WEST SUSSEX COUNTY COUNCIL CONSULTATION

TO:	Arun District Council FAO: Michael Eastham
FROM:	WSCC - Highways Authority
DATE:	9 October 2020
LOCATION:	Land South of Water Lane Angmering
SUBJECT:	A/157/20/DOC Approval of details reserved by condition imposed under ref A/99/17/OUT relating to Condition Nos 9 - noise mitigation, 11 - highways, 12 - refuse & recycling bins and 21 - Construction Management Plan.
DATE OF SITE VISIT:	n/a
RECOMMENDATION:	Advice
S106 CONTRIBUTION TOTAL:	n/a

Appendix C – Routing Plan

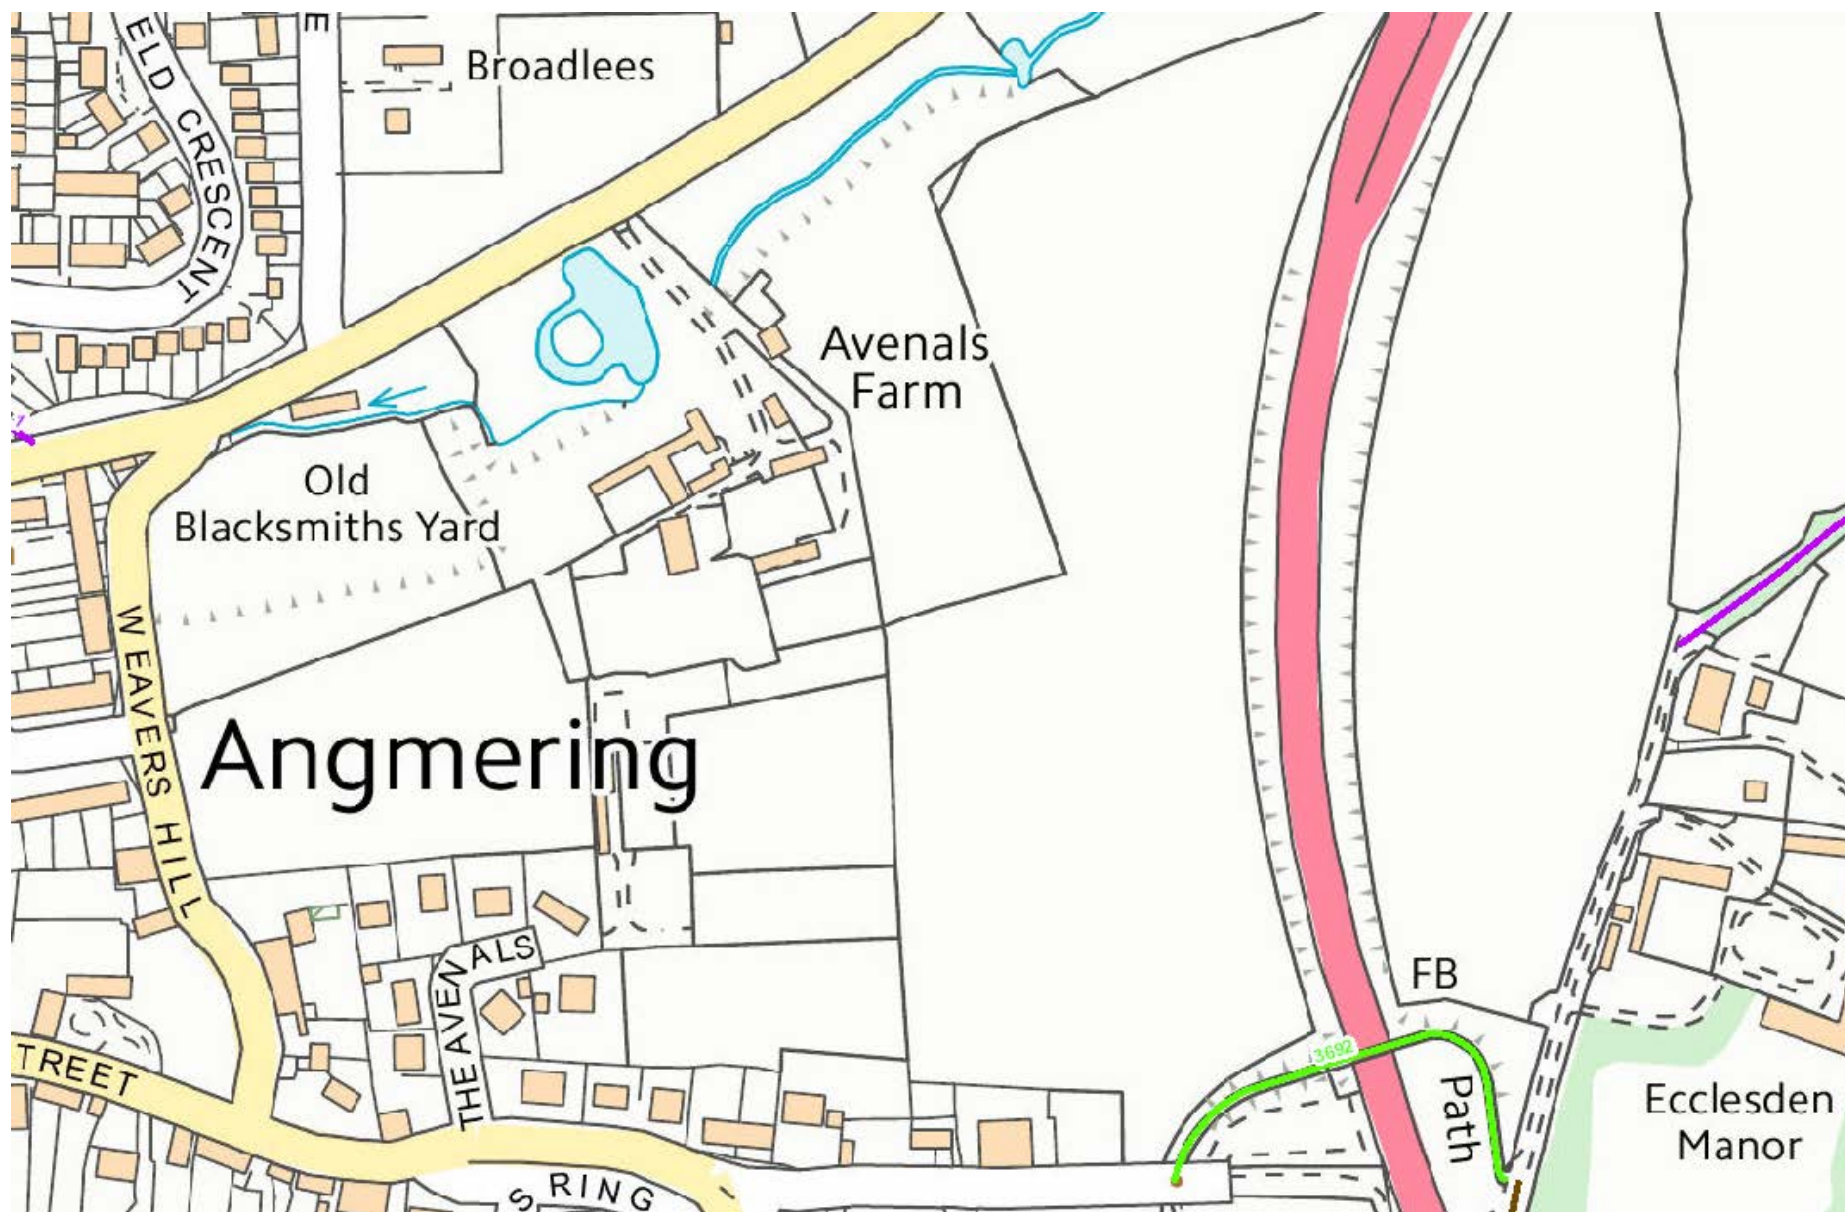
A wider traffic routing plan must also be provided; HGVs should not access the temporary access or for that matter the permanent access via Angmering village. A pre-condition survey must also be undertaken of all construction routes to be used by construction traffic not just High Street as the CMP indicates. This ideally should be completed with a member of WSCC Highways present. The applicant would be responsible for meeting the cost of any repairs associated with the increase of HGV traffic resulting from the construction of the development.
